Health Central Coast Local Health District

I write in response to your email of 20 December 2019, regarding the State Significant Development Application 10414, mixed use development at 8-16 Watt Street, Gosford (Gateway site).

Thank you for the opportunity to review the Secretary's Environmental Assessment Requirements (SEARS) and Concept Application for the Gateway site project. The Central Coast Local Health District's (the District) Health Planning, Health Promotion, Public Health Services and Clinical Services have collaborated to prepare this response.

1 BASEMENT 1
DA534 1 : 500

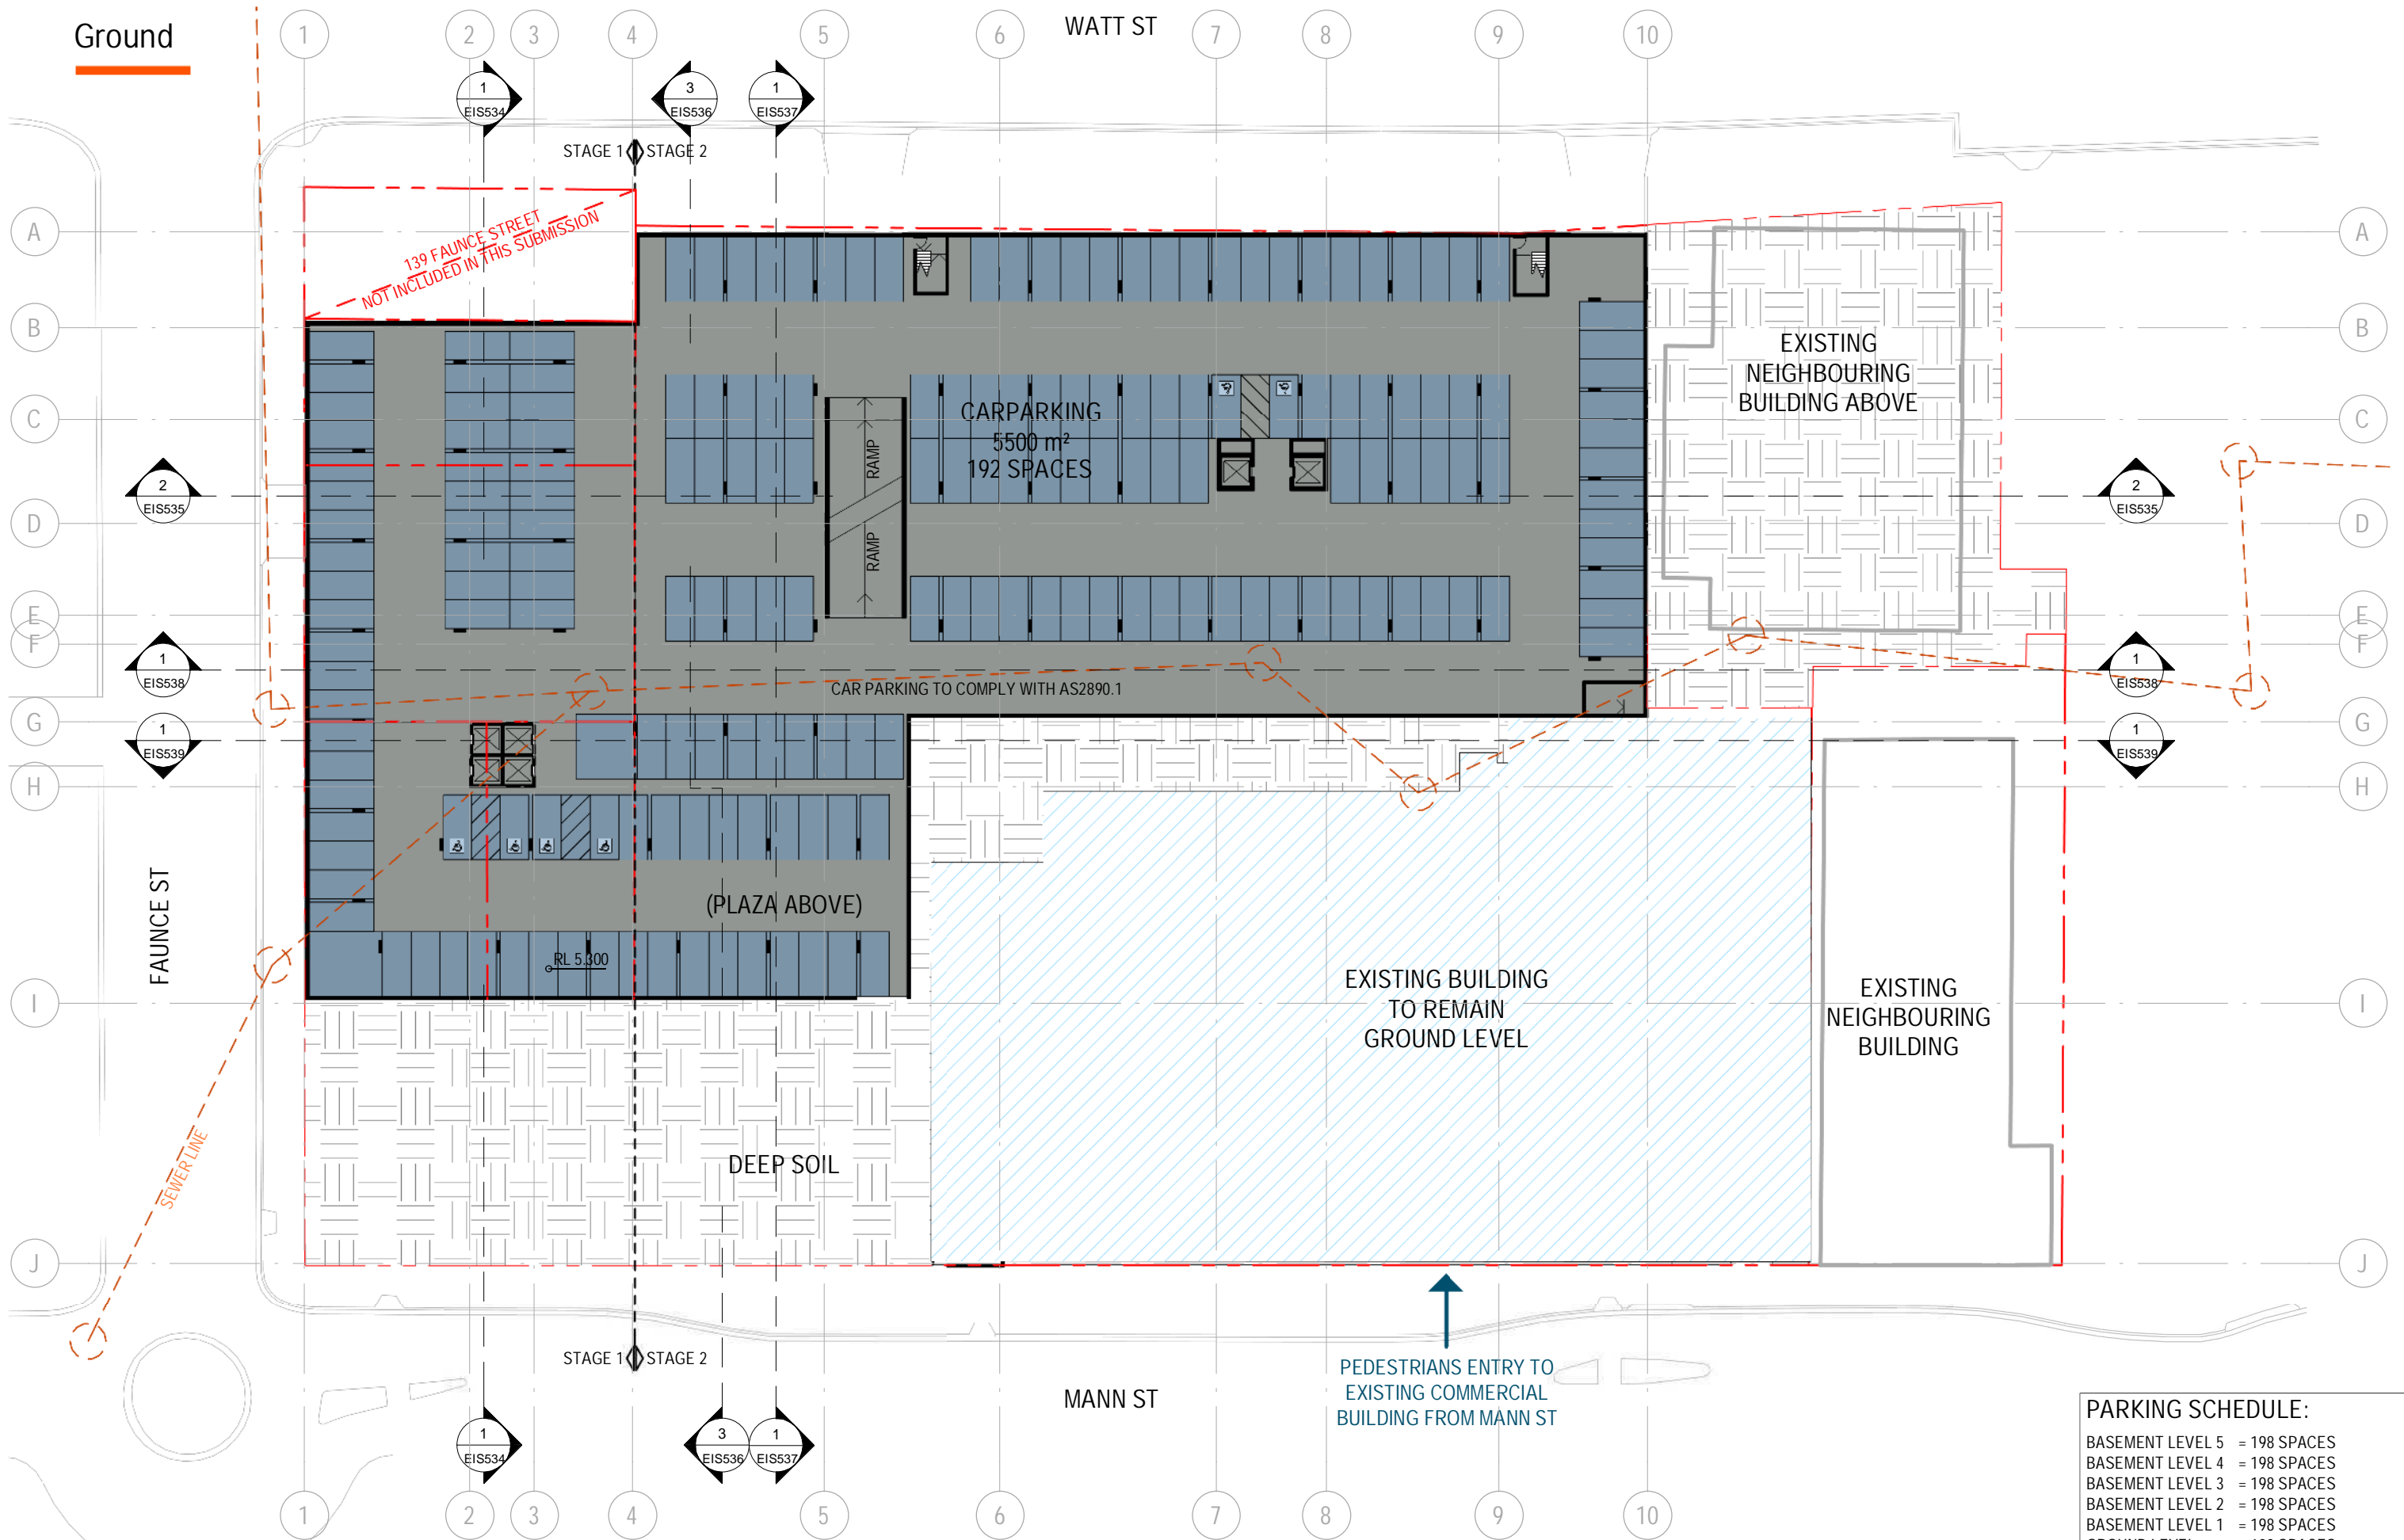
- for car parking, the anticipated number of car parking spaces to be made available and how these numbers will be distributed between the proposed residential and commercial/retail areas
